STERLING RANCH FILING 2-MARKSHEFFEL ROAD BETWEEN VOLLMER ROAD - STERLING RANCH ROAD

STREET IMPROVEMENT PLANS

FEBRUARY 2018

Interim
VOLLMER ROAD
STA 33+00.00 TO STA 45+34.37

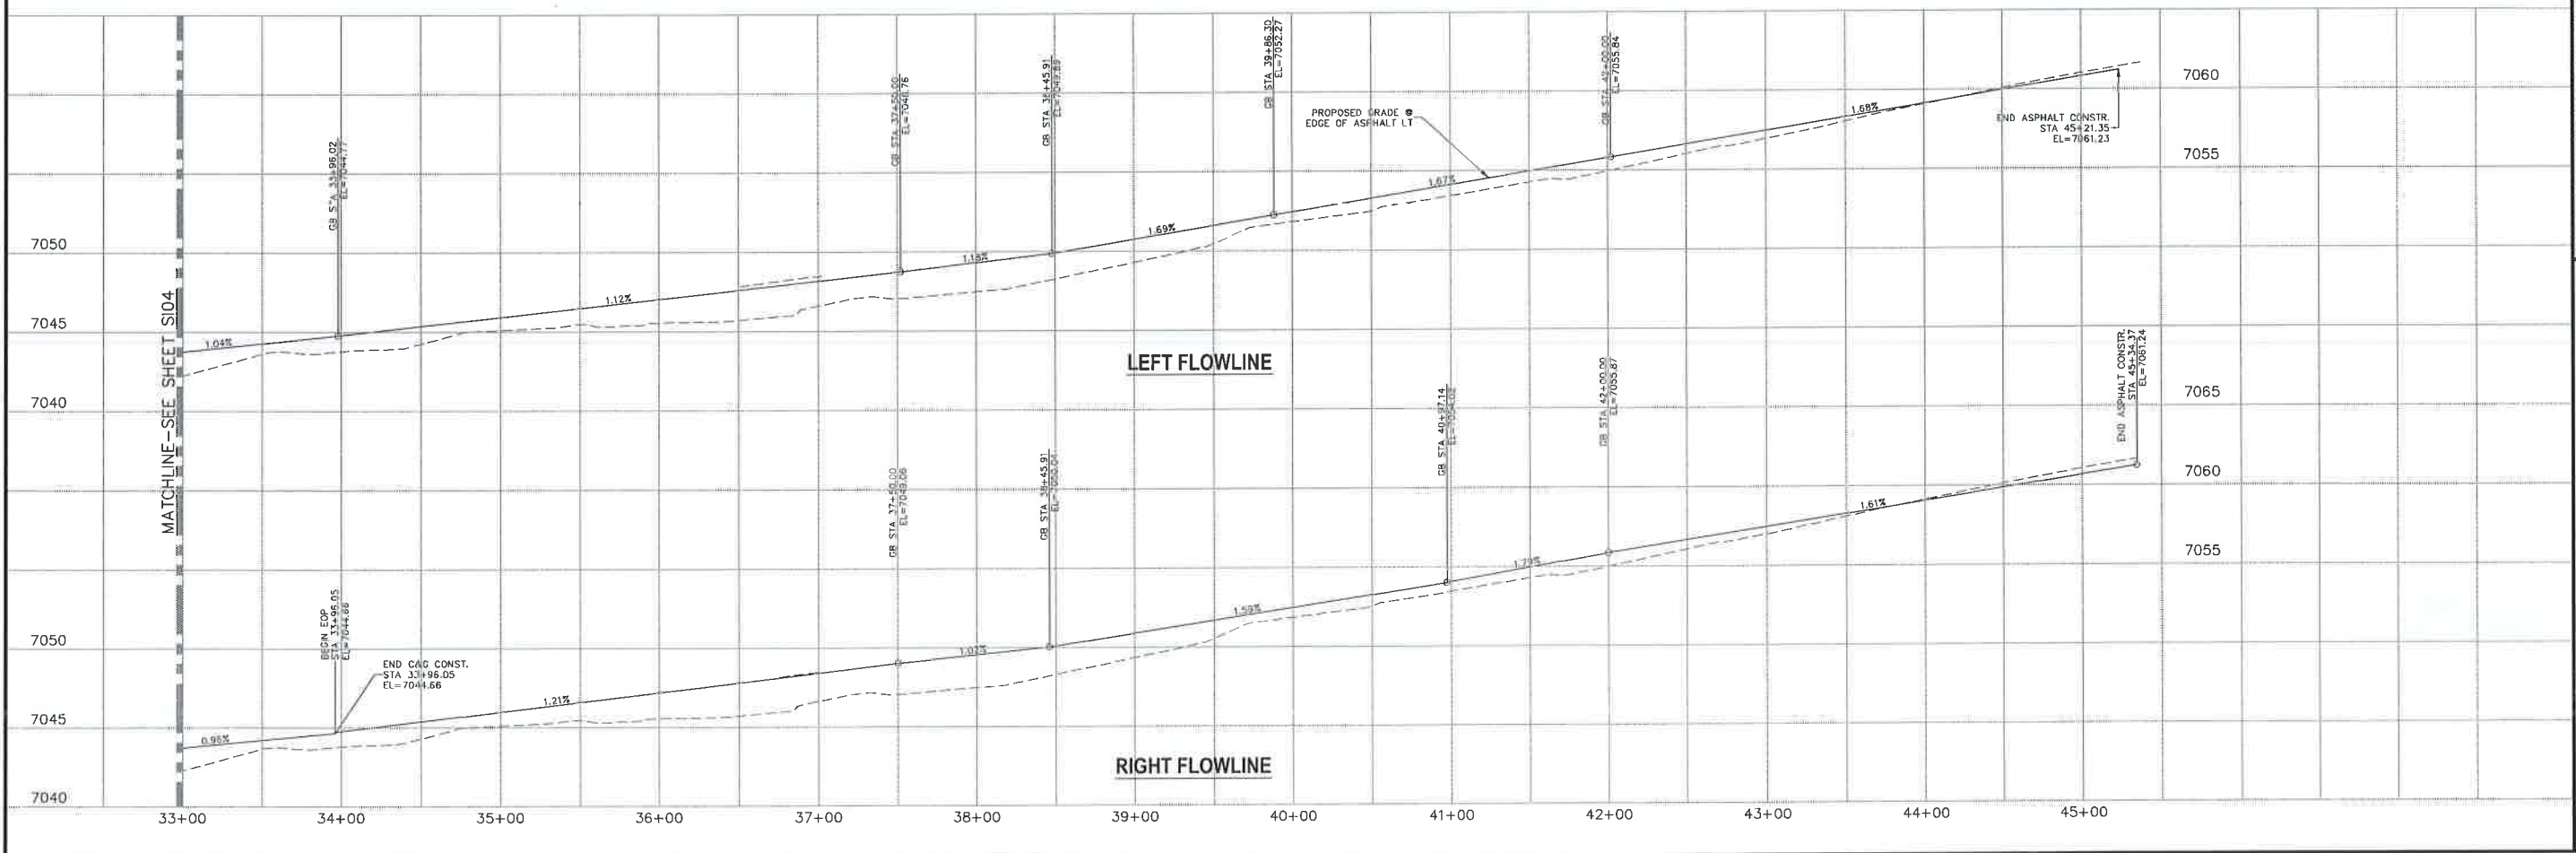
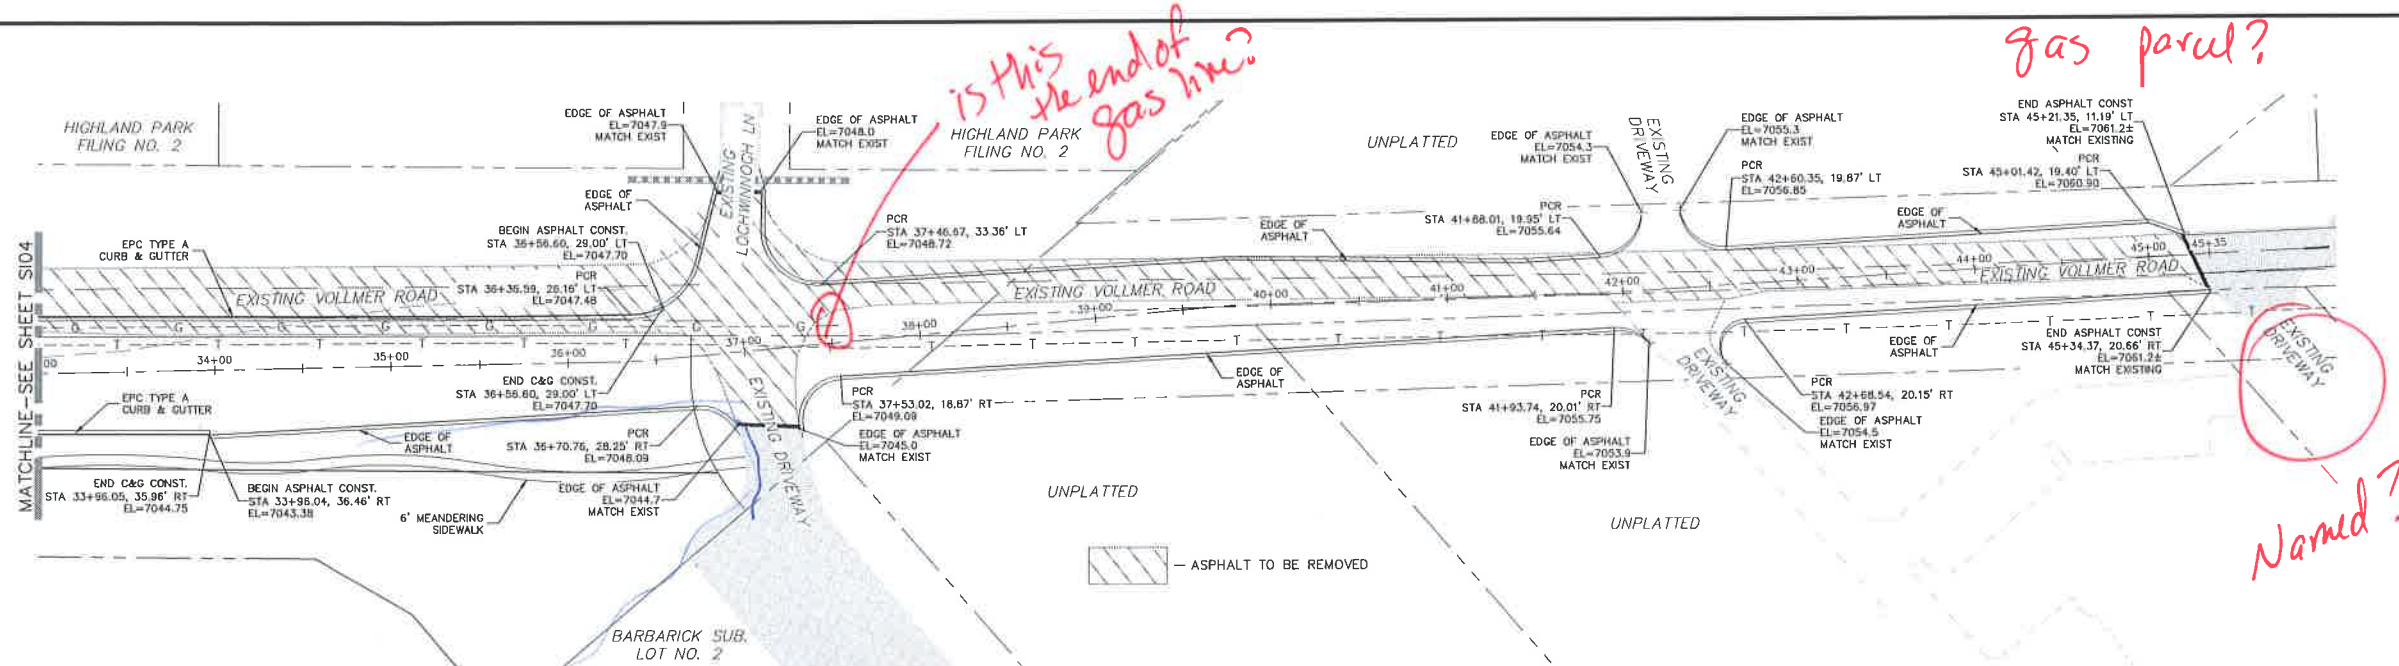
Curb and gutter should be added in this section through the curb return for the South side of the Barbarick Subdivision driveway. Including Pedestrian ramps etc.

Construct to full width.
